Letter No. A2/23109/96

Sub: MMDA - Planning Permission - ^{Regularisation} Construction of residential/commercial building at plot No.78, Kandaswamy Nagar, in S.No.117 of Palavakkam Village. Development charges and other charges to be remitted - Regarding.

ELEVATION

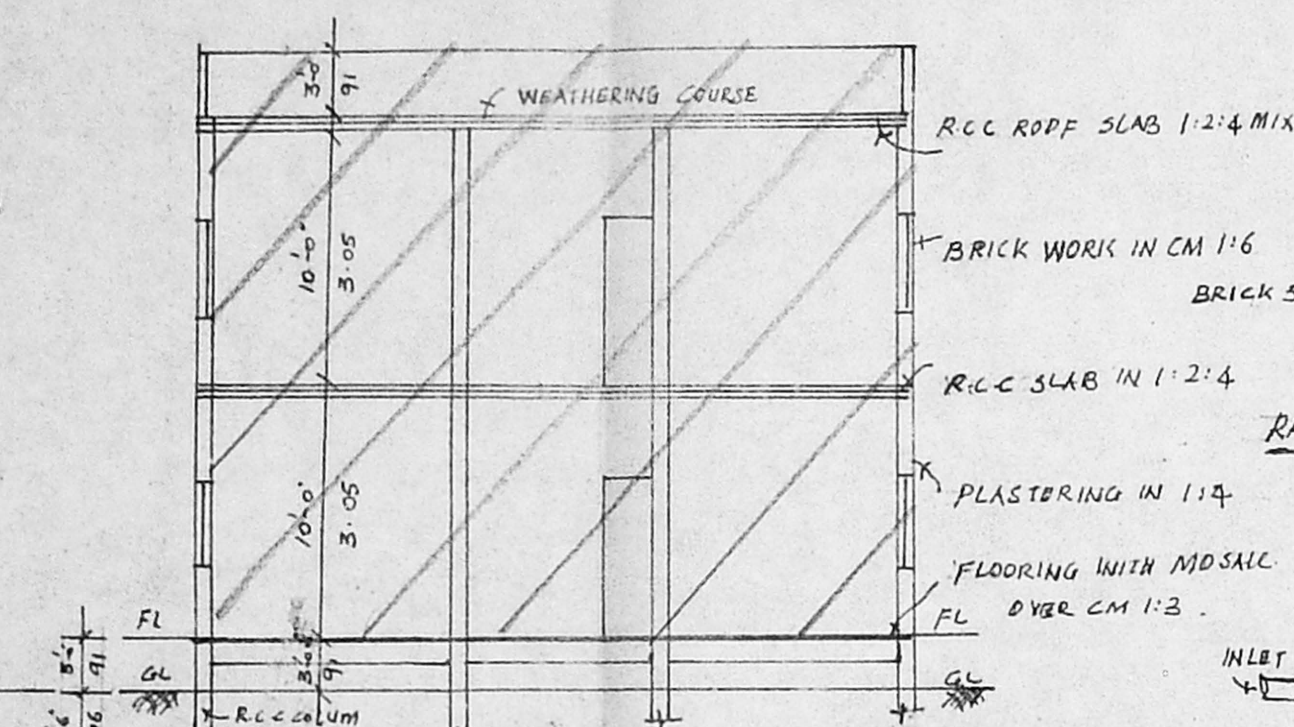
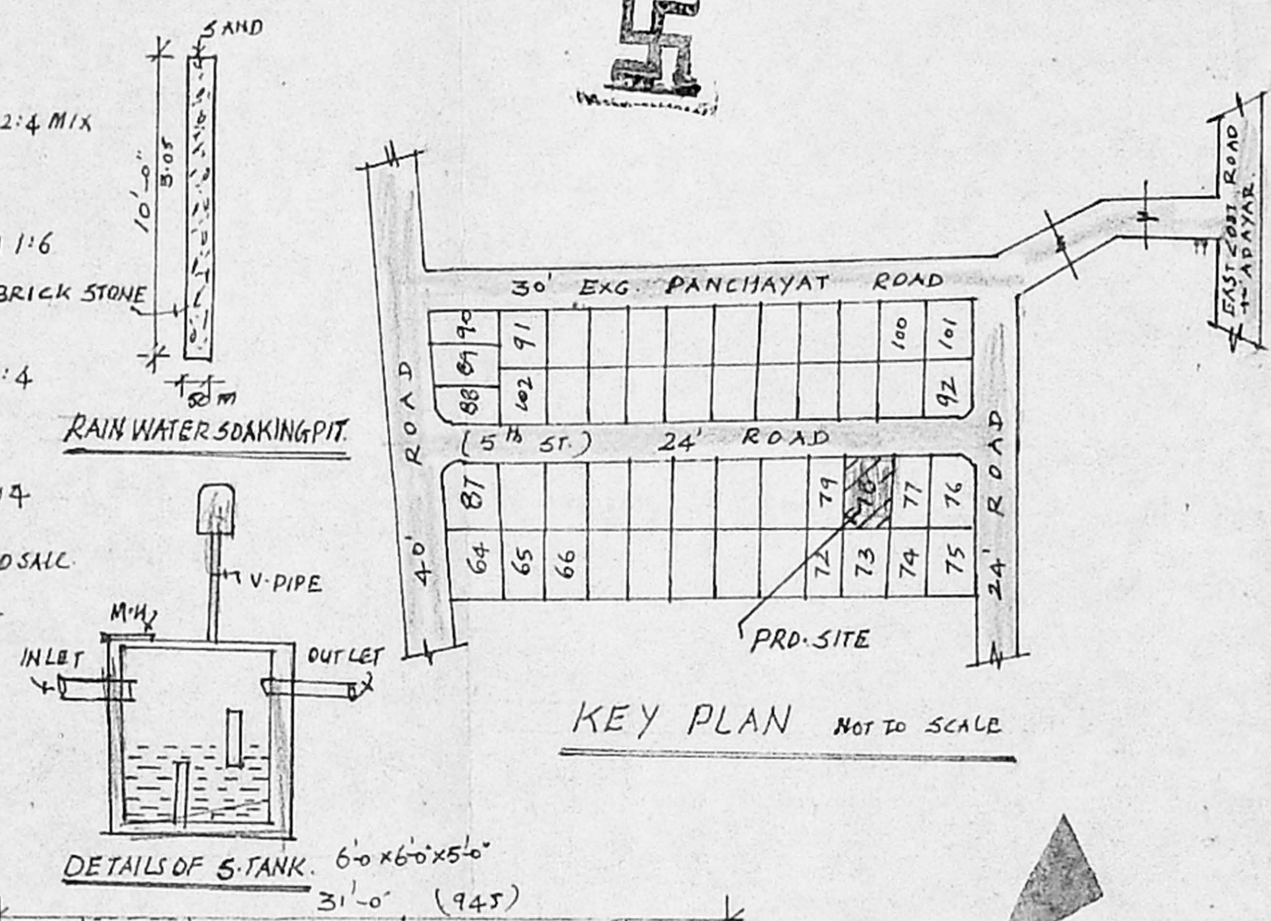
5 copies of plan without int correction and showing the head room in the elevation
